**Consultation Response from: KC Environmental Health (Pollution & Noise Control)**
**2023/92926 - Stiches, 10 Commercial Street, Batley, WF17 5HH**
**Change of use from retail shop to hot food takeaway and installation of extract vent to rear (within a Conservation Area)**
**Responding Date:  
02 January 2024**
**Responding Officer:  
Mohammed Nasim**
**Responding Ref:  
WK202338689**
**Comments**
**Noise**

**PROPOSED REAR ELEVATION**  
SCALE 1:100

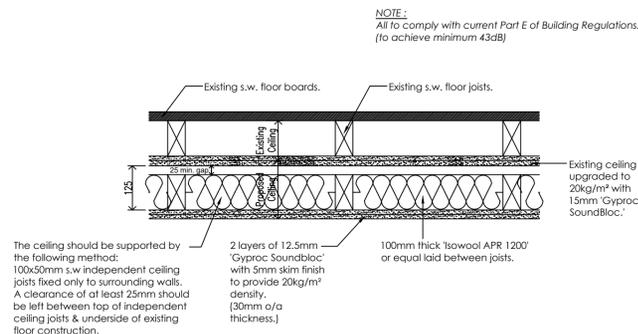
The applicant has submitted an undated and unreferenced document titled Proposed Extract Ventilation System which makes reference to the Guidance on the Control of Odour and Noise from Commercial Kitchen Exhaust Systems” document from DEFRA. The applicant is advised that this document was withdrawn in 2017 and replaced with the Control of Odour & Noise from Commercial Kitchen Exhaust Systems - EMAQ May 2022. However, the principles remain the same and the risk assessment is scored as follows –

We question the submitted assessment based on the size of kitchen which we believe should be scored as 3 and also the cooking type which should be scored as 10. We believe the nature of the proposed takeaway warrants the higher scores which would raise the impact risk to very high thus requiring a very high level of odour control. The findings of the submitted assessment recommends works for a high level of odour control and so therefore, we reject it and recommend a condition for an Odour Impact Assessment to be submitted. The applicant is

Before food cooking commences, details of a kitchen extract system shall be submitted to and approved in writing by the Local Planning Authority. The details shall provide the following information:

- A risk assessment for odour which considers amount and type of food that will be cooked together with the proposed dispersion of odours and proximity of receptors likely to be affected by any cooking odours.

- Based on the risk assessment, details of the proposed methods of odour control and dispersion of any extracted odours. The effective stack height (discharge height plus plume rise) must be high enough to ensure that adequate dilution takes place before the plume interacts with the nearest sensitive receptor.

- Details showing the proposed location of all the major components of the extract system.
- The noise mitigation measures that will be incorporated in the extract system and details of the likely resulting noise levels that will be caused by operation of the extract system, in particular how loud it will be at nearby noise sensitive locations.

**DETAIL 1:  
NEW INDEPENDENT CEILING (Existing)**  
Scale - 1:10

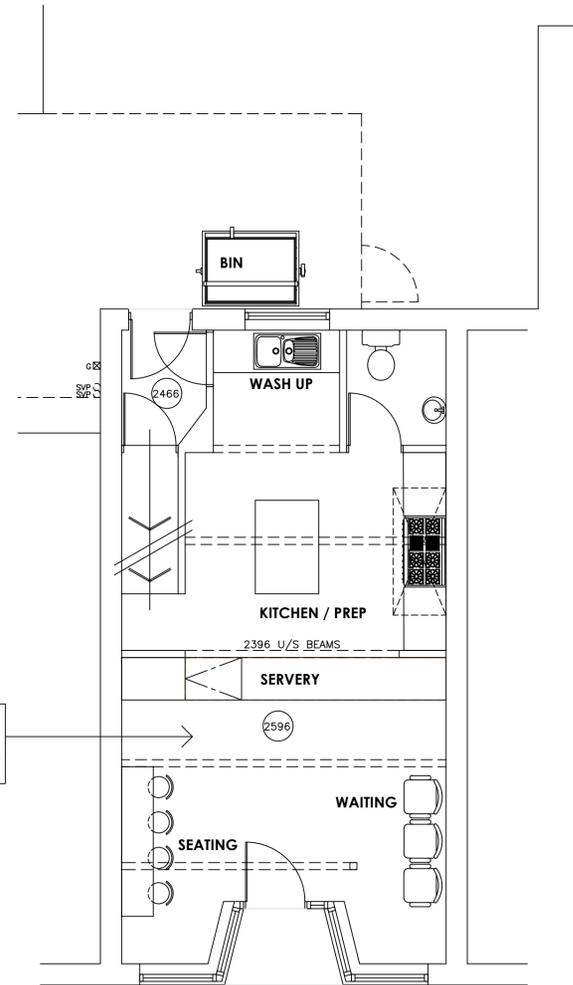
A new ceiling is proposed but the applicant will need to ensure it meets with a higher standard than stated. A condition is recommended for a Sound Insulation Assessment to be submitted to protect the amenity of neighbouring properties.

Before the development is brought into use written evidence to demonstrate that the airborne sound insulation performance of the party floors/walls/ceiling of the development is of a minimum of 55dB  $D_{ntw} + C_{tr}$  shall be submitted to and approved in writing by the Local Planning Authority. If it cannot be demonstrated that the aforementioned airborne sound insulation performance has been achieved, a scheme incorporating further measures to achieve the sound insulation performance shall be submitted to and approved in writing by the Local Planning Authority. All works comprised within those further measures shall be completed and further written evidence to demonstrate that the aforementioned sound insulation performance level has been achieved shall be submitted to and approved in writing by the Local Planning Authority before the development is first brought into use.
